Central Coast Quarter 26 Mann Street Gosford

RTS RESPONSE PACK

REV C

MASTERPLAN DEVELOPMENT REVIEW TIMELINE

Figure 3 – Southern Tower Articulation

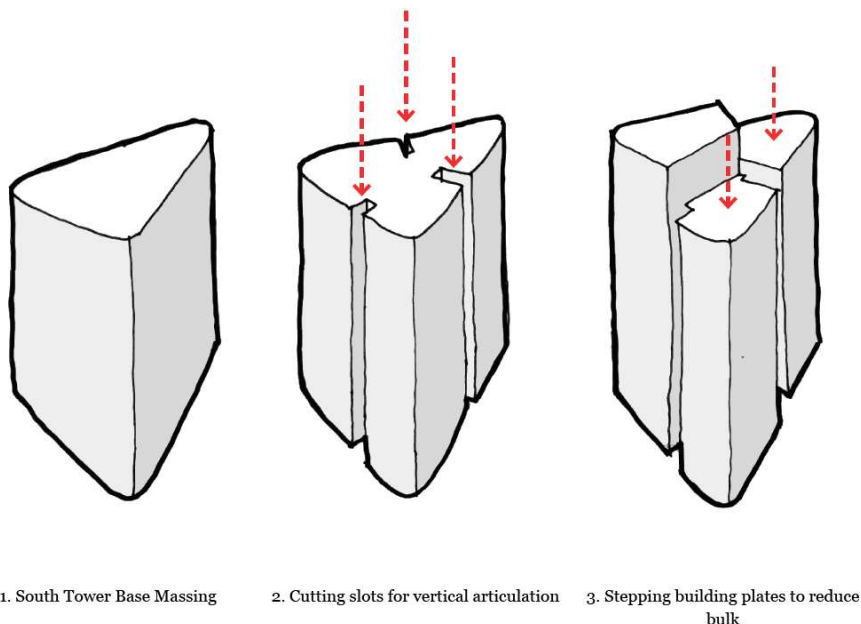
2. The southern tower is short, squat and undifferentiated. The panel recommends that it be differentiated/broken in to separate segments, and the heights shifted so that the southern corner (Vaughan Ave/Baker St corner) is the lowest corner (stepping or tiering is recommended).

- 1) Reducing the mass and bulk of the Southern Tower envelope, so that it presents as a more slender tower form, reduces its visual dominance from key vantage points and enhances views through the site.
- 2) Reducing the height of the Southern Tower envelope, to be sympathetic to Gosford's natural setting, including the ridgeline and the Waterfront, and improves solar access impacts to Leagues Club Field, Poppy Park and Memorial Park.
- 3) Relocating the Southern Tower envelope, to be further setback from the southern corner of the site, as well as Vaughn Avenue and Baker Street.

The massing of the Southern Tower has been articulated to break down the perceived bulk and scale from a single tower into two slender towers by creating a continual vertical break on all sides. In addition to the vertical articulation, the tower is stepped to create 3 differing heights with the southern corner being the lowest.

The massing of the Southern Tower has been articulated to break down the perceived bulk and scale from a single tower into multiple slender towers by creating a continual vertical break on all sides.

Figure 4 – Southern Tower Expression

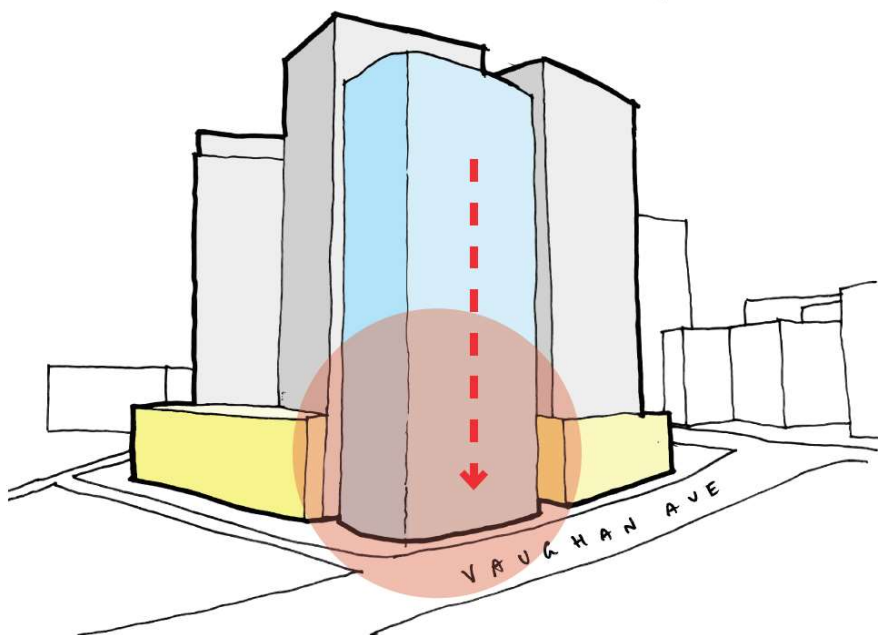
3. The Panel recommends that consideration be given to continuing the expression down, removing the commercial frontage on Vaughan Avenue and replacing it with residential down to street level.

The corner of the Southern tower is brought down to the street level, further accentuating the split in the massing. In addition to the vertical articulation, the envelope of the Southern Tower has been stepped down allowing for increased solar access to the Leagues Club Field, Poppy Park and Memorial Park.

The corner of the Southern tower is brought down to the street level, further accentuating the split in the massing. In addition to the vertical articulation, the envelope of the Southern Tower has been stepped down allowing for increased solar access to the Leagues Club Field, Poppy Park and Memorial Park.

Figure 5 – Revised Mann St Interface and Through Site Link

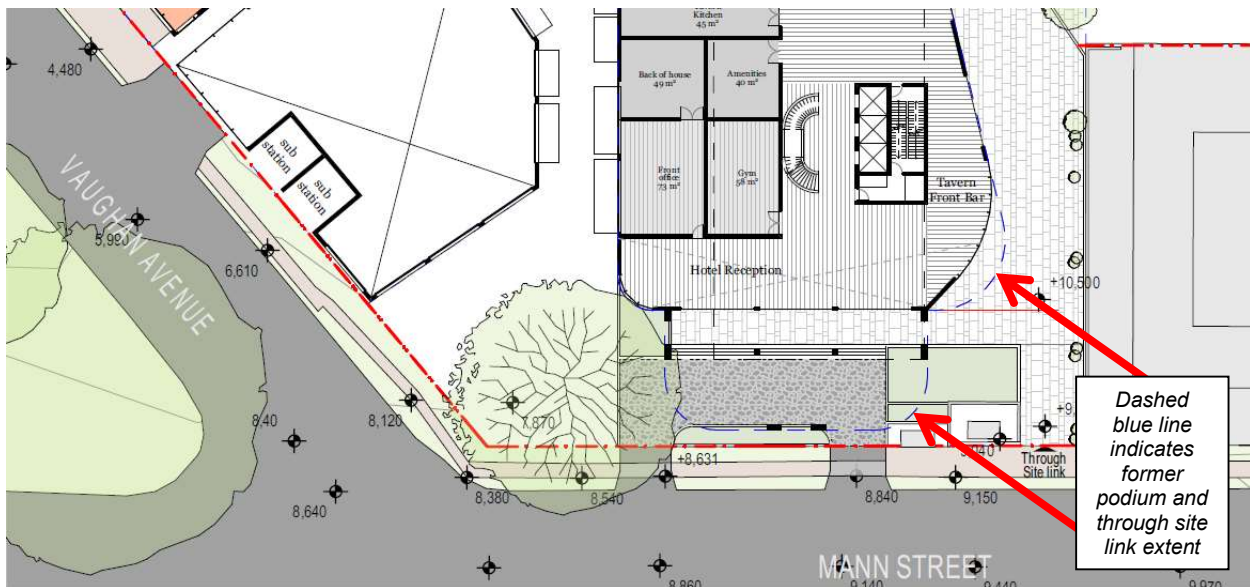
- 4) Providing additional vertical articulation in all the buildings, to reduce the perceived bulk and scale of the buildings when viewed from key vantage points (this may be specified in the design guidelines above).
- 5) Relocating the Eastern Tower envelope to increase the setback from the podium street wall to respect the scale of Mann Street.
- 6) Increasing the width of the northern through site link to provide greater amenity for the site's public domain.

Eastern tower envelope has been revised to increase setback from the podium wall to 6m. Podium footprint has been revised to increase the width of northern through site link for increased amenity to the public domain.

Figure 6 – Vertical Articulation of Towers

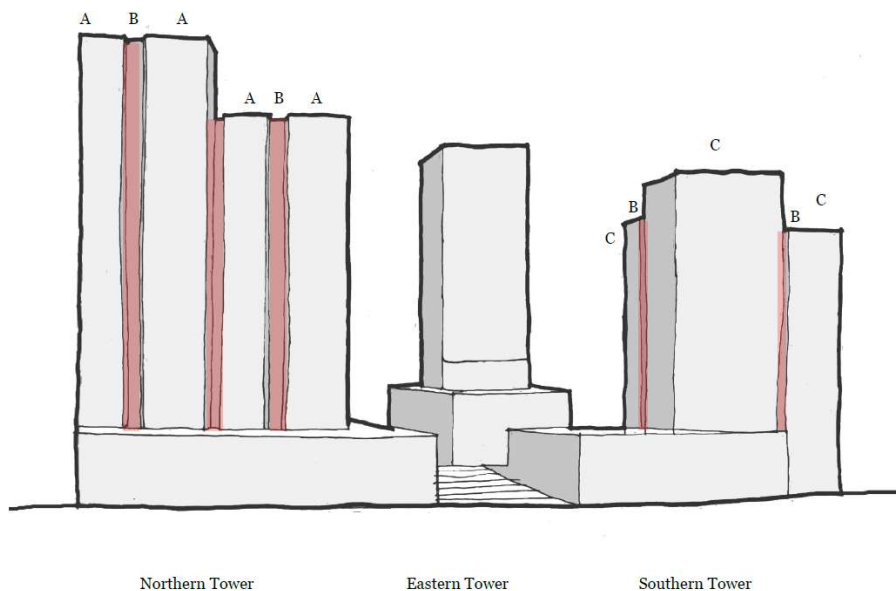
4. The Panel recommends that the northern tower have greater articulation with slender towers and variable roof levels, as they were in the version presented to the Panel in May 2019.

The Northern tower is articulated in the same manner with a vertical break along the long face of the massing to create two slender towers. the tower form is stepped with variable roof levels as well as the Northern portion of the tower sitting proud of the massing to further the expression of two towers.

Additional articulation has been added into all buildings, mainly the North and South buildings. In the Northern building, stronger vertical breaks have been incorporated to further reduce the outlook and bulk of the tower. Whereas, this is done in the Southern Tower through slots and step down of massing, to create a perception of two smaller tower forms rather than one.

Figure 8 – DKO Shadow Drawings

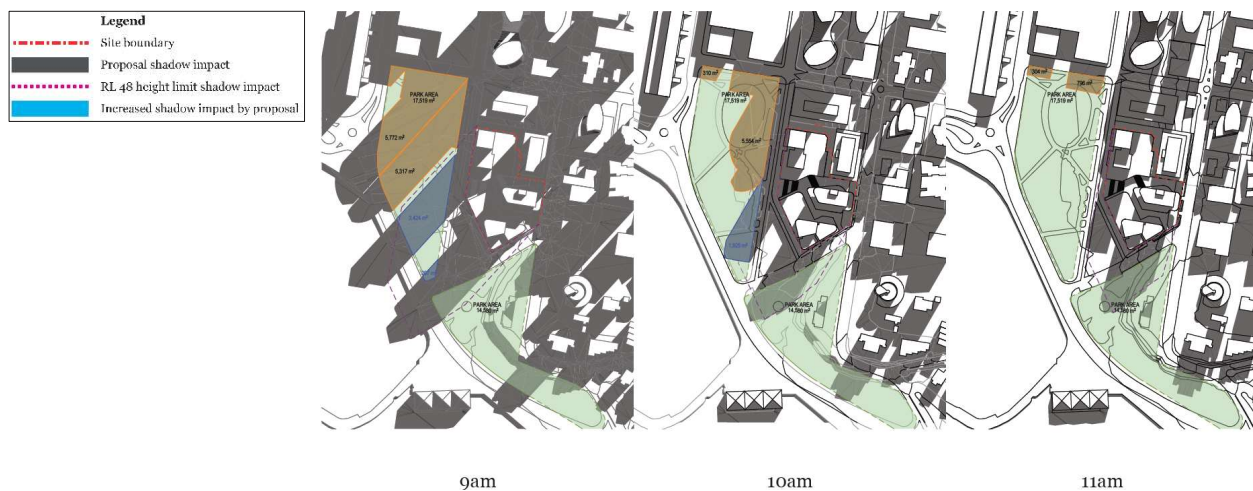
7) Noting Council’s concerns about potential solar and amenity impacts associated with the proposal, the Department requests amended shadow diagrams showing the solar access impacts (for summer and winter solstice and spring and autumn equinox, at hourly intervals between 9am and 3pm) to the surrounding public domain, including Leagues Club Field, Poppy Park, the Memorial Park and the Waterfront and likely solar access to the proposed through site links.

Shadow diagrams have been provided for summer and winter solstice and spring and autumn equinox. 100% of Leagues Club Field receives 4 hours of direct sunlight. Memorial Park and Poppy Park only affected by proposed between 10am and 11am.

In comparison to the proposed scheme, the RL 48 Scheme overshadows the park for an additional 800sqm between the hours of 9-10am (approximately 11% more overshadowing than the proposed scheme)
